City of Albuquerque Stormwater Construction Site Inspection Report

| Project Name and Location | Rain Tunnel Car wash COURS and Savilla | | |

| Project Name and Location | Rain Tunnel Car crash Coors on Sutil | | |

SITE PLAN

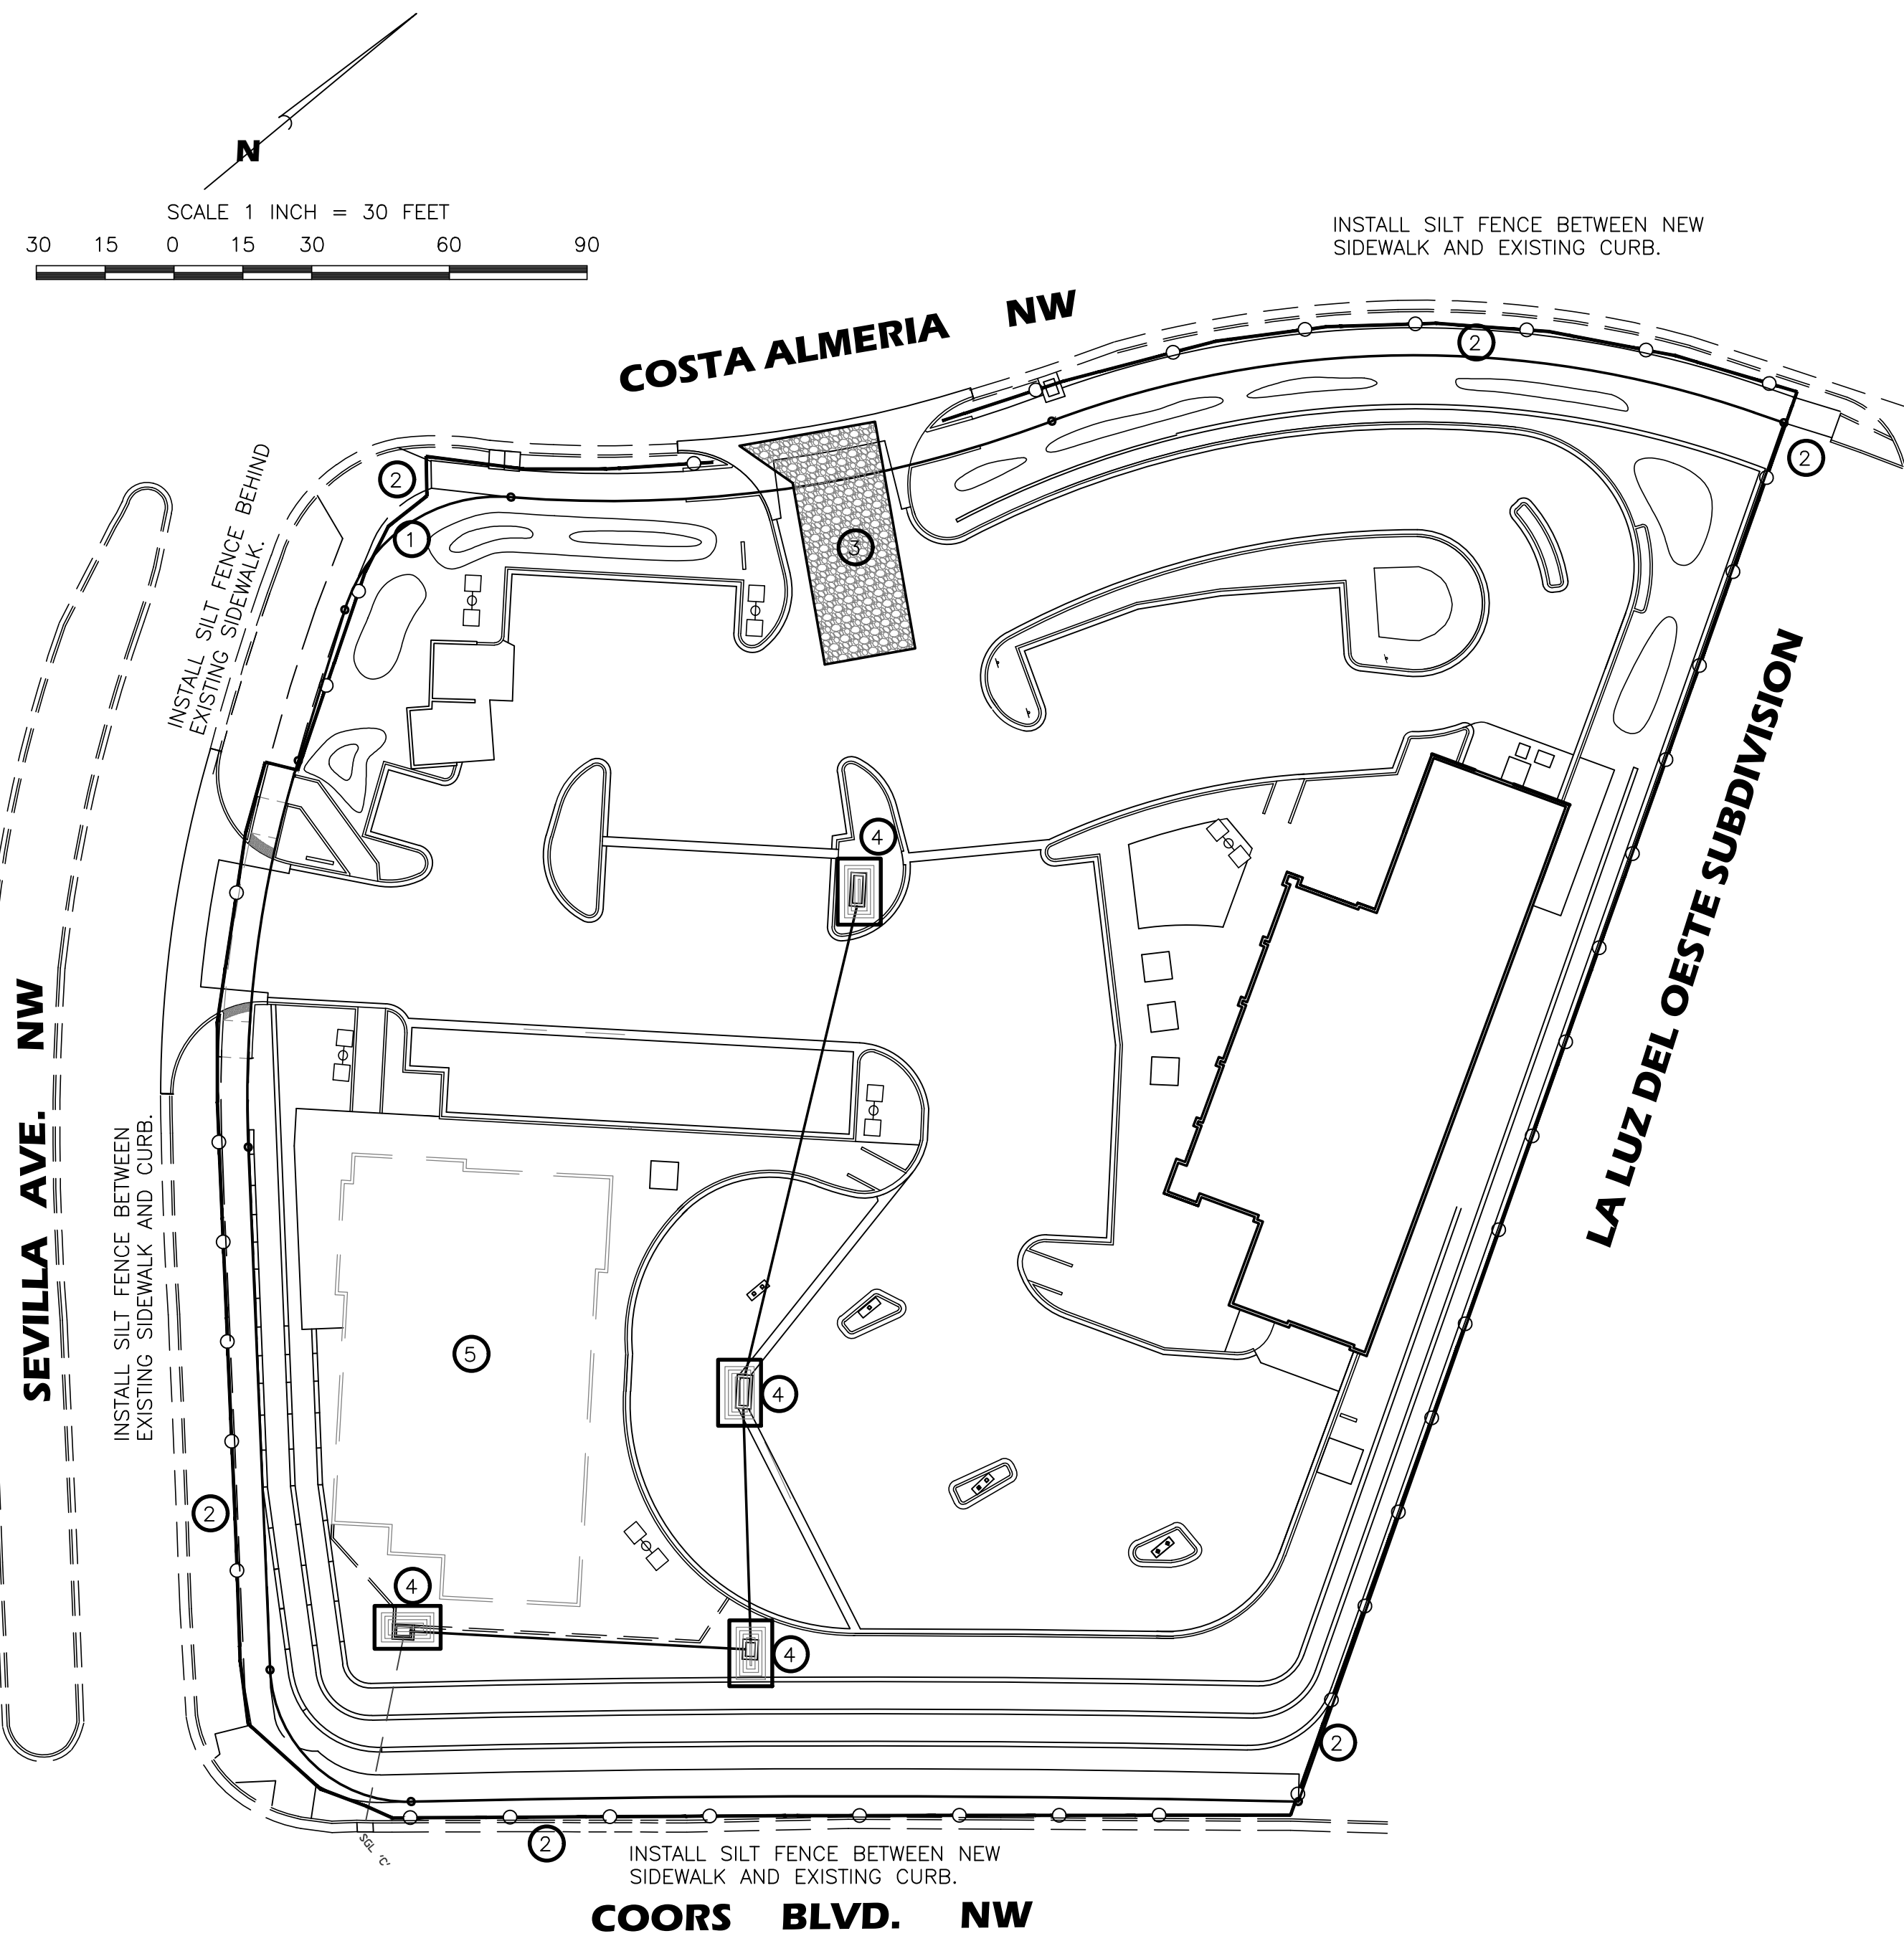
I didn't see a pic of the sediment BMP near the NW corner to fill the gap between the wall and the existing silt fence.
Issue #3 in email dated 9-27-18.

| Entrance / Track-Out | pad - require maintain at project end - main track-out asphalt ramp to curb may be source of sediment |
| Sediment Controls / Silt Fence, Inlet Protection, Wattles, etc. | gap in sediment BAP north edge Sediment going over wall north side - midway from sock, silt fence is down 2' min for 3 ft fence wall |
| Housekeeping/Pollutant Controls | wash-out is leaking, want lean silt |

Please find the attached picture to reflect the changes made to the NW corner gap. The second picture attached reflects the rock added to the trackout pad on 09/28/18.

Thank you again for your time today. I will keep a much closer eye on the block wall to the north side. With that being said, the cut back has been maintained, wattles installed and additionally the construction exit has been swept. Please let me know if you have any additional questions or concerns.
